The Ottawa Hospital New Civic Development

UDRP Presentation

January 2023

UDRP Feedback, June 2023

2 BUILDING SECTION THRU LIGHT WELL N-S
1:200

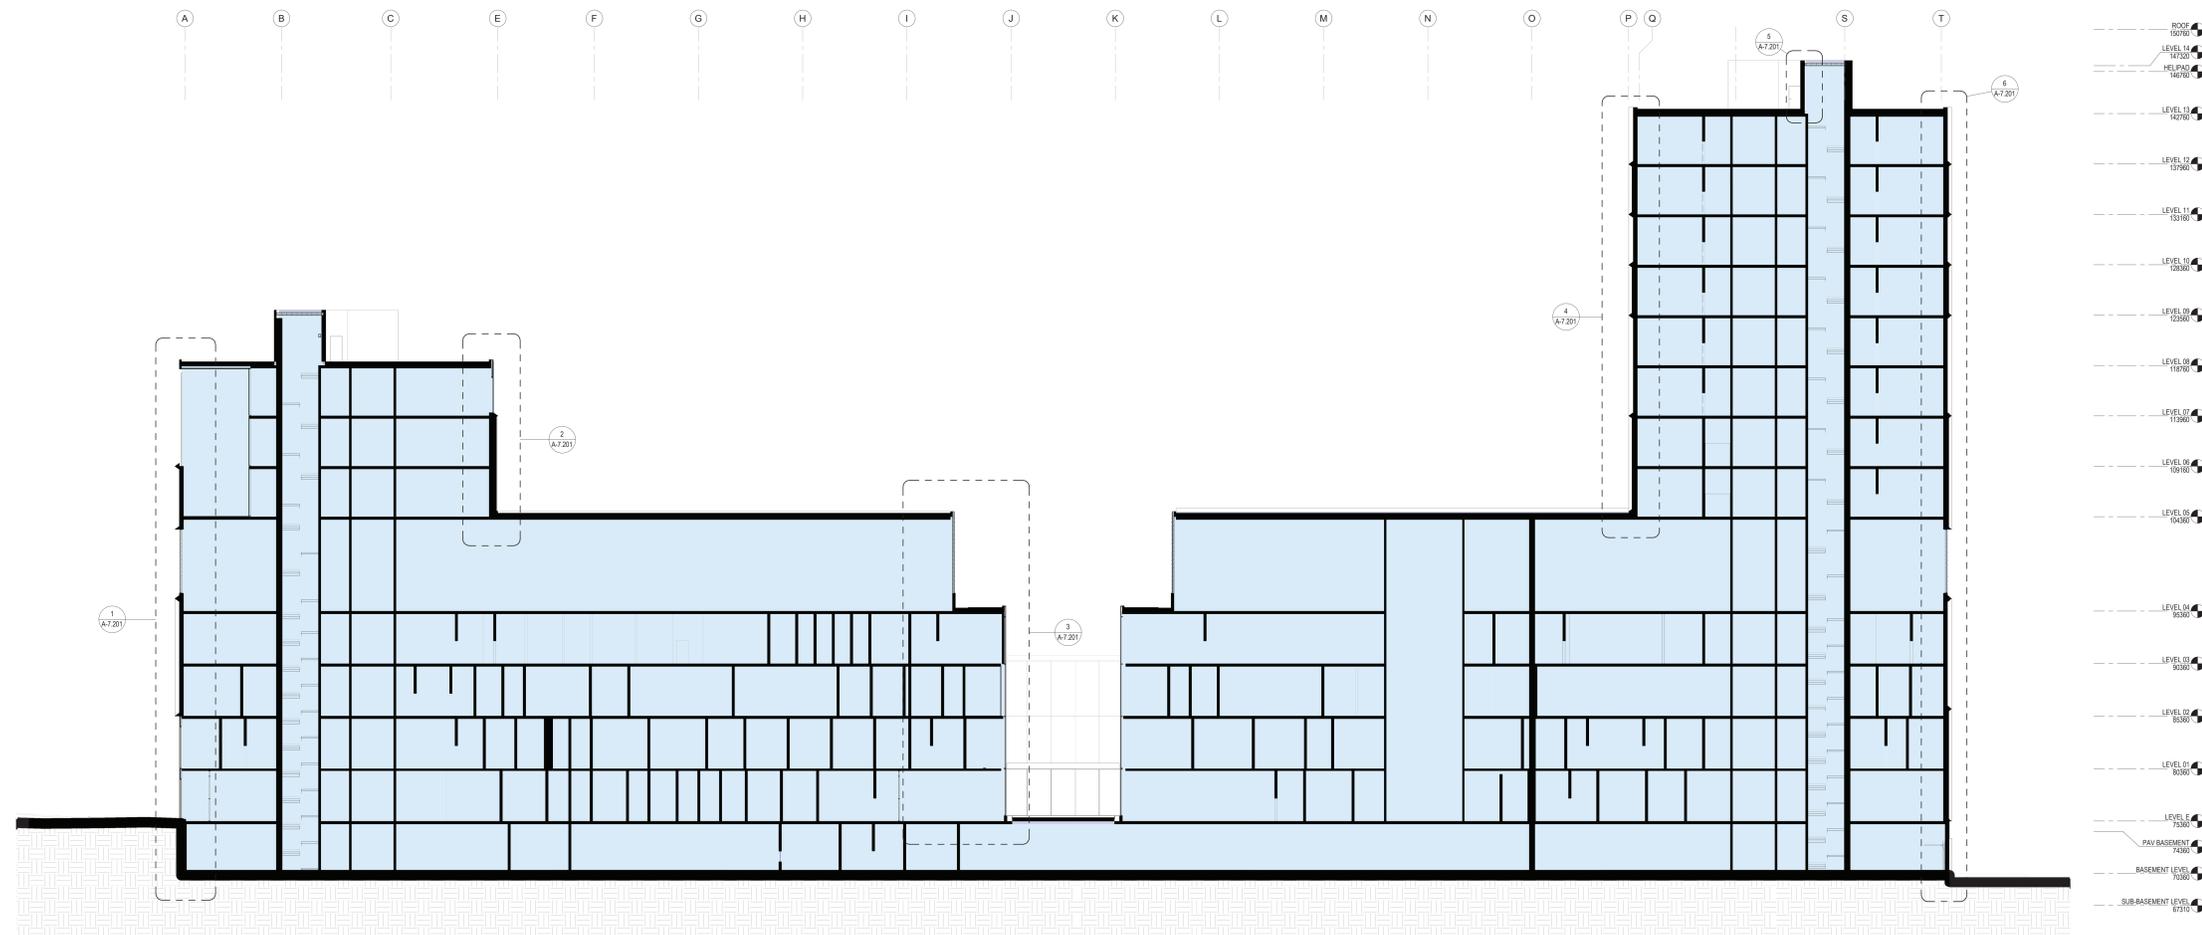
The proponent should consider bringing the light well forward to create a well-defined feature to tie the entrance.
